Response from Guardians of the East Coast (GOTEC) to Meeting with Inspectorate Tuesday 25<sup>th</sup> June 2024

4.14 Washingdales Lane Block Valve Station Plan and Elevations

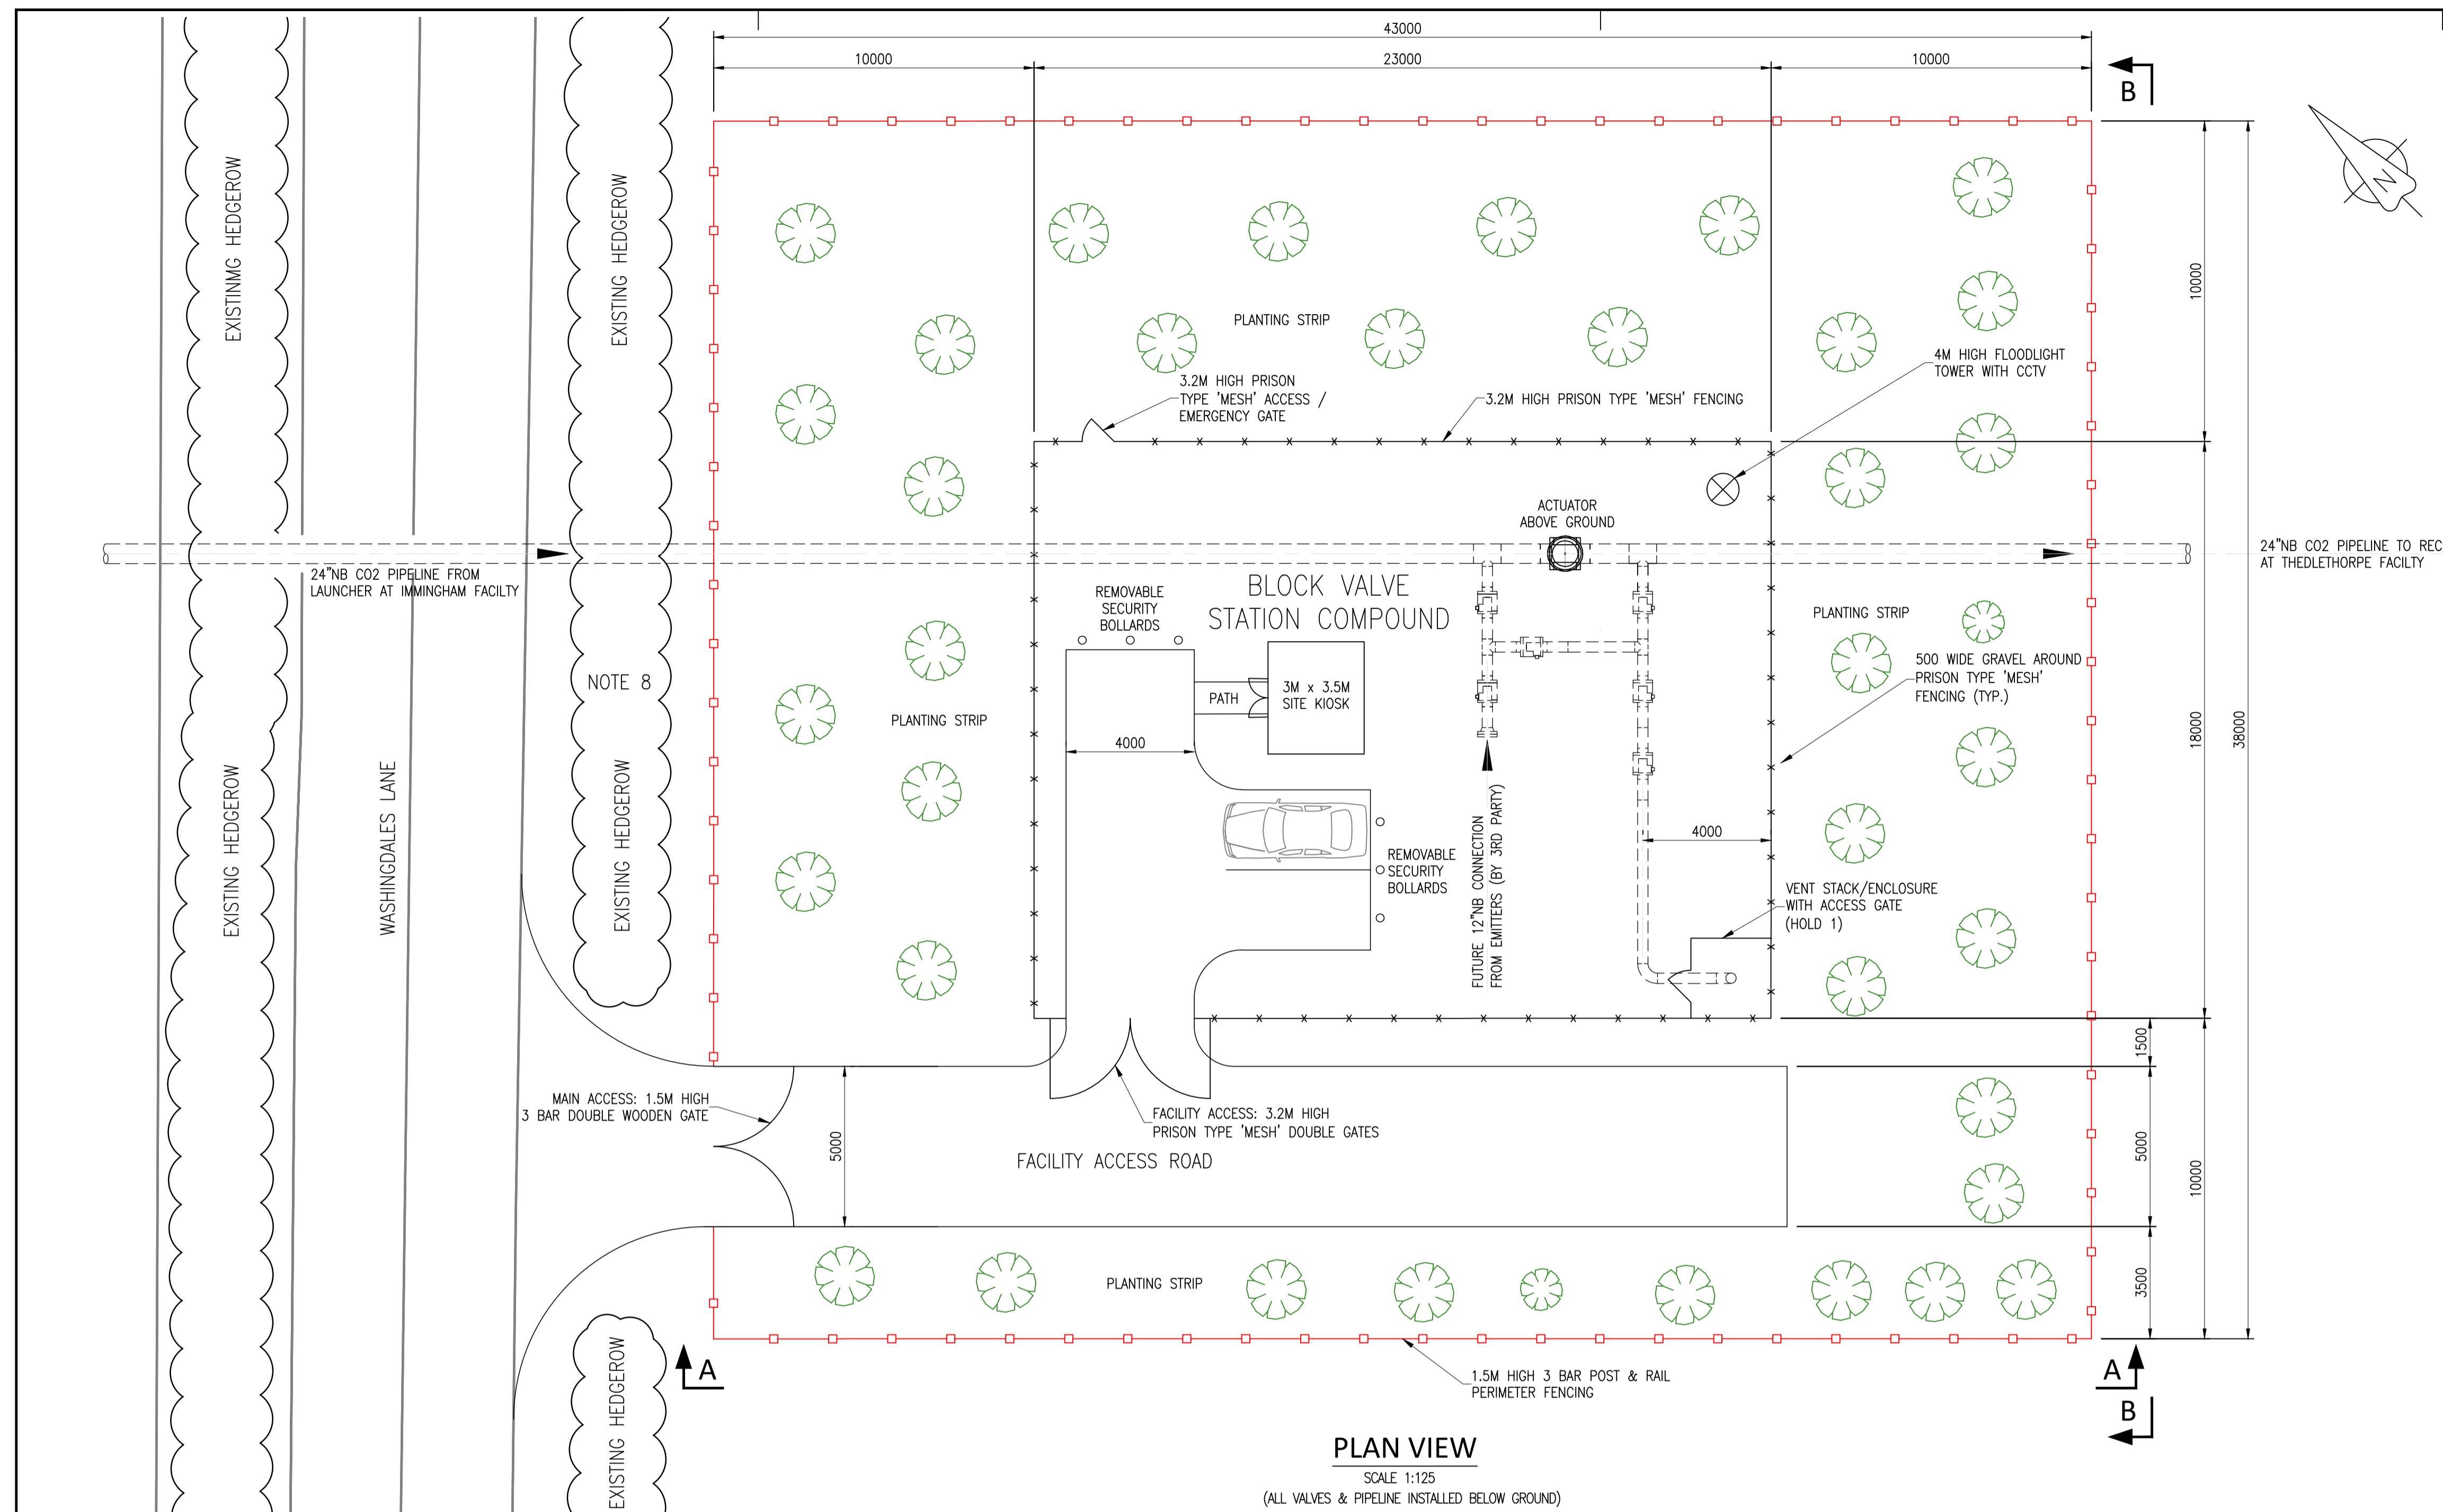
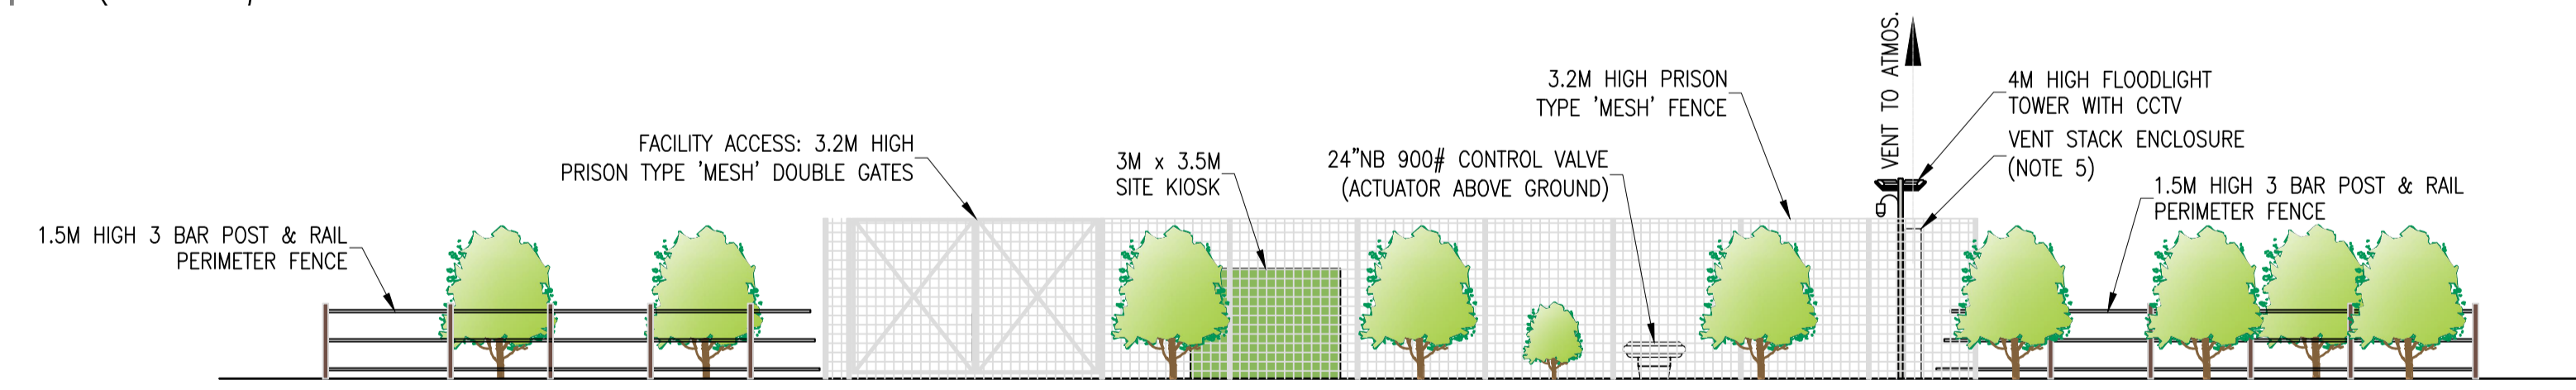
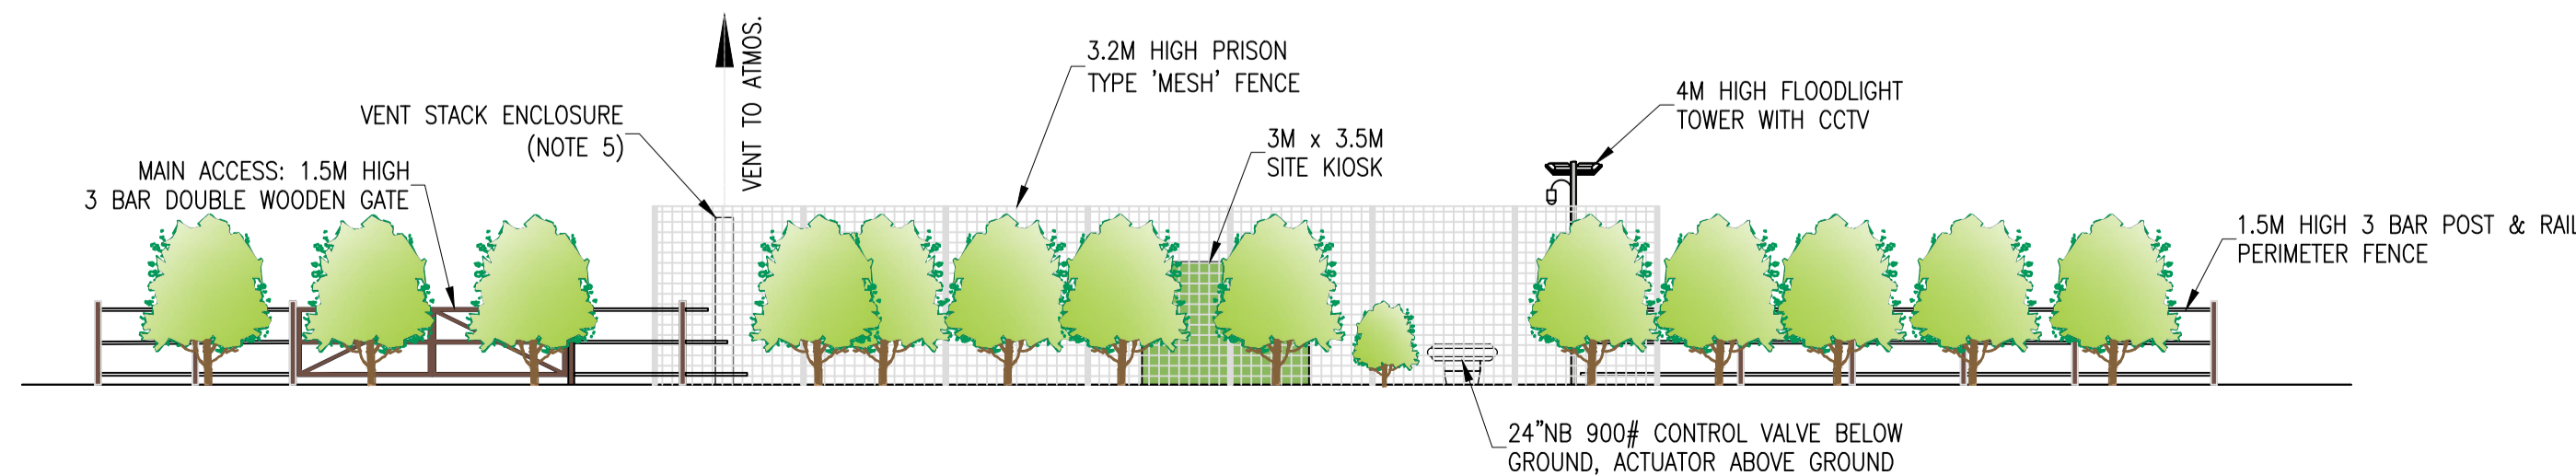
7. Block valve selection – I assume the block valves will be standard oil and gas valves as used in hydrocarbon pipelines. I have concerns over the selection of these valves as the elastomer in a dense phase environment will suffer impregnation of CO<sub>2</sub>. Subsequent depressurisation will most likely result in explosive decompression of elastomers thereby rendering the valve inoperable and unable to provide a competent seal. Also it should be noted that the extreme ranges of temperature as acknowledged by the applicant due to the Joule-Thomson effect are likely to cause embrittlement of any plastic components, seals, o-rings and elastomers

Traditional block valves rely on wetting of the surfaces to facilitate a competent seal, due to the properties of Supercritical/ Dense phase CO<sub>2</sub> it has a very low surface tension and will therefore make it difficult to achieve a competent seal until sufficient differential pressure is experienced across the valve and the valve paddle moves onto the seat with sufficient force to elicit a seal but this very function is likely to exacerbate the likelihood of explosive decompression of the elastomer. A further complication of the poor wetting condition is that while achieving the required differential across the valve a degree of fluid cut, scouring and phase transition with potential for Clathrate/Hydrate formation may occur due to pressure transition from high pressure jet to the lower pressure environment immediately downstream of the valve thereby releasing energy and causing rapid cooling of the liquid phase CO<sub>2</sub>. Worst case scenario in this instance is that the assumption is made that the valve closure has been successful but in actual fact a hydrate is blocking the pipe and work commences only for the hydrate to melt and there be a sudden release of high pressure CO<sub>2</sub> into the work area and local environment.

Figure 2. Preliminary modelling with vent stack height of 20m

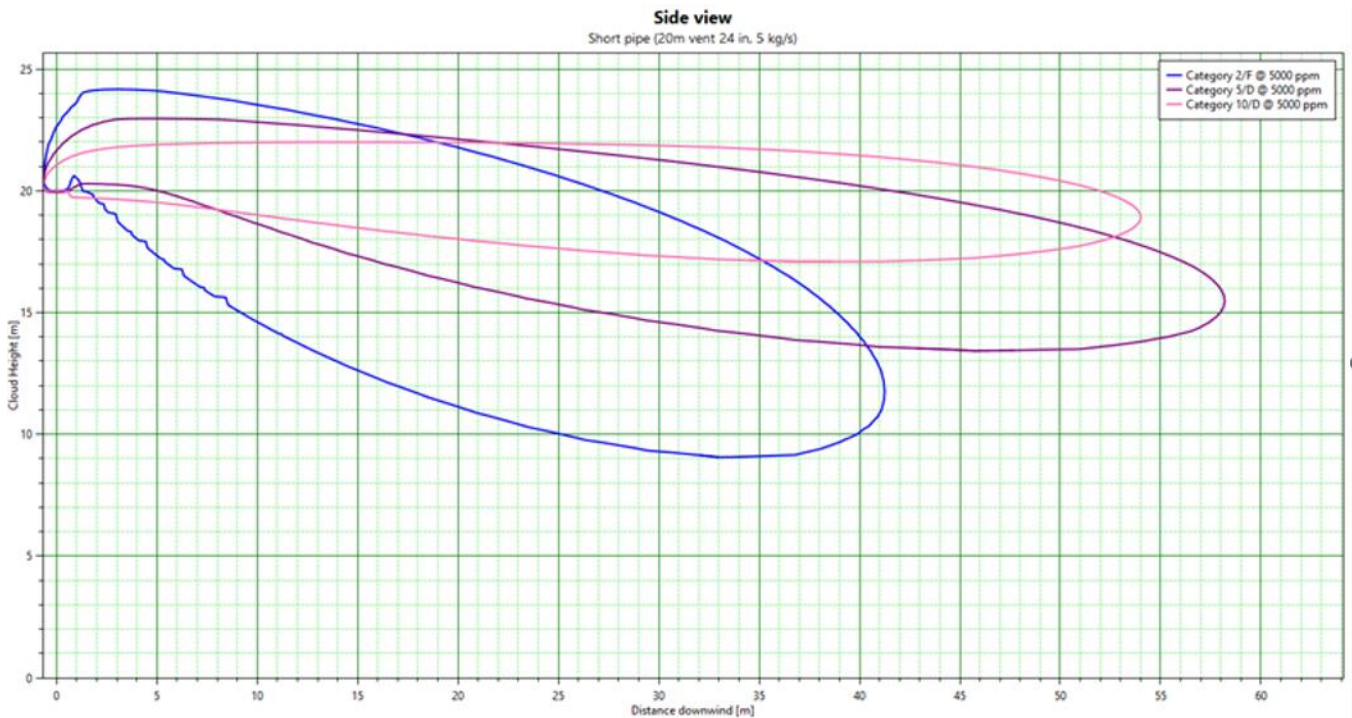
9. In the applicants response they state “it has been demonstrated in section 2.3 of this technical note that a 20-25m high vent will be sufficient to ensure safe dispersal” – yet all the data presented is “preliminary and indicates” (section 1.3.4 ) not has been comprehensively tested and been proven to a high level of certainty. Sections 2.3.4 & 2.3.5 both start with “preliminary modelling” and 2.3.5 continues with “assuming atmospheric conditions that would represent a realistic worst case scenario” what atmospheric conditions do they assume – those which allow them to say a 20-25m stack is suitable?
